Rezoning Petition Review

Date of Review: October 29, 2020

Rezoning Petition #: 20-134

Location of Property: Approximately 26.59 acres located along the east side of Rhyne Rd, south of Mt Holly Rd and west of I-485.

**RZ-1.0**

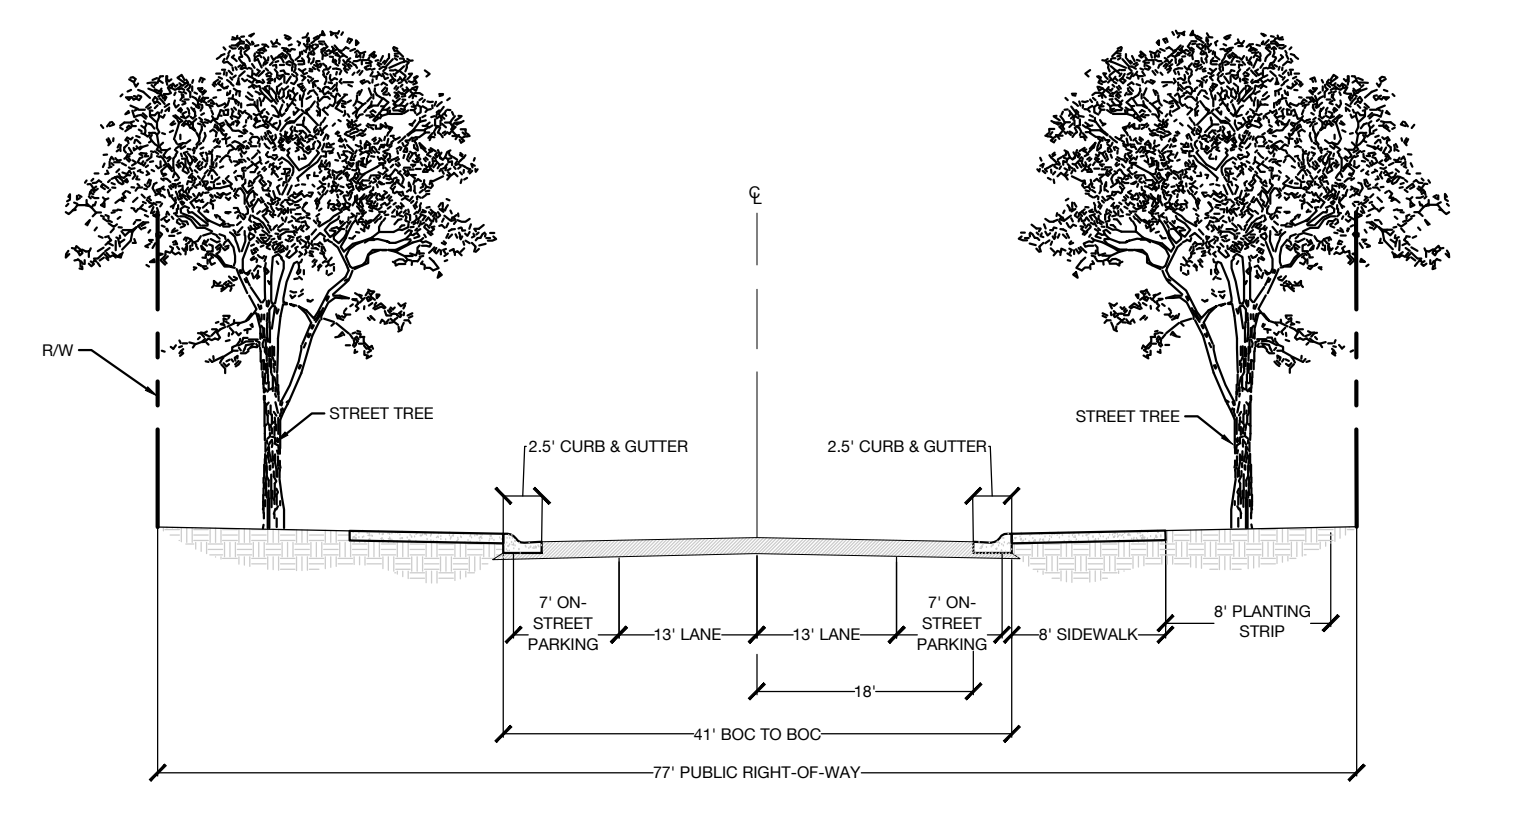
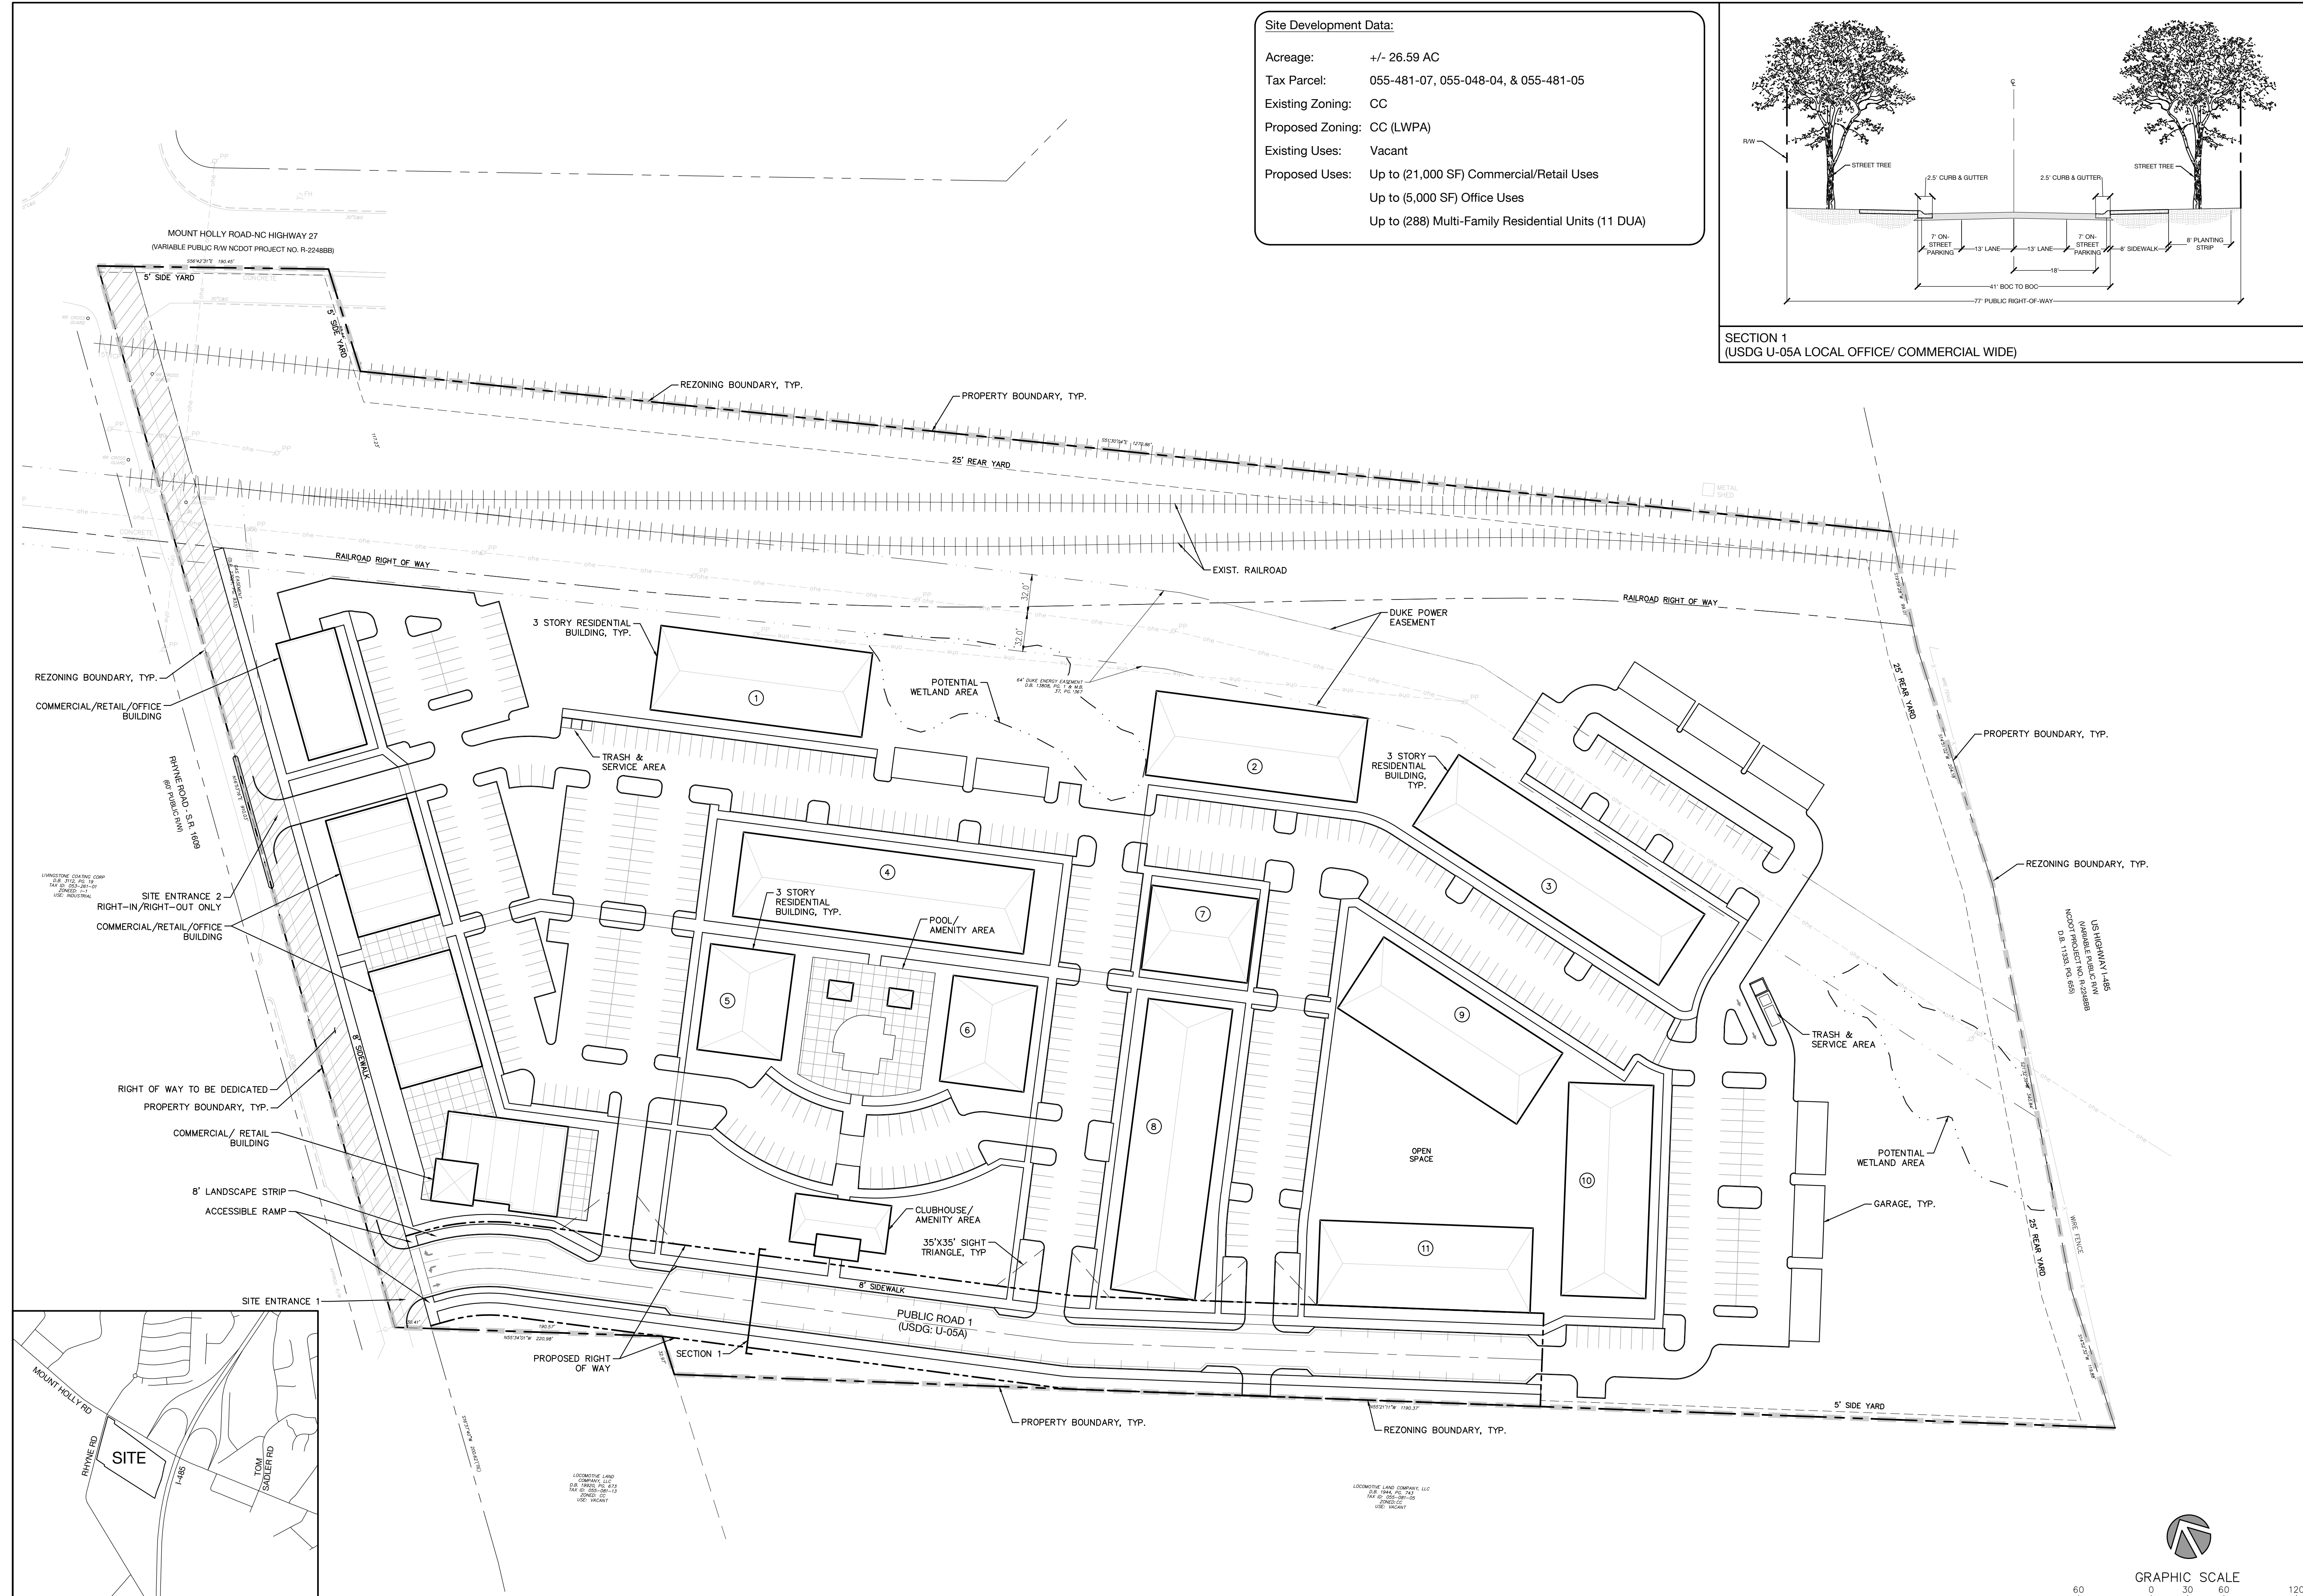
Concerning Storm Water: City of Charlotte GIS data indicates a 30-ft PCSO buffer across the northern and eastern property lines of the site. Please show and label *Potential 30-ft PCSO Buffer* on the site plan. Any increase of impervious area within such buffers may not be allowed and is not approved with the rezoning process. Stream Delineation Reports are subject to review and approval by Charlotte Storm Water Services. Please include the following note under Environmental Features: *“Development within any SWIM/PCSO Buffer shall be coordinated with and subject to approval by Charlotte-Mecklenburg Storm Water Services and mitigated if required by City ordinance. Petitioner acknowledges intermittent/perennial stream delineation reports are subject to review and approval upon submission of development plans for permitting and are not approved with rezoning decisions.”*
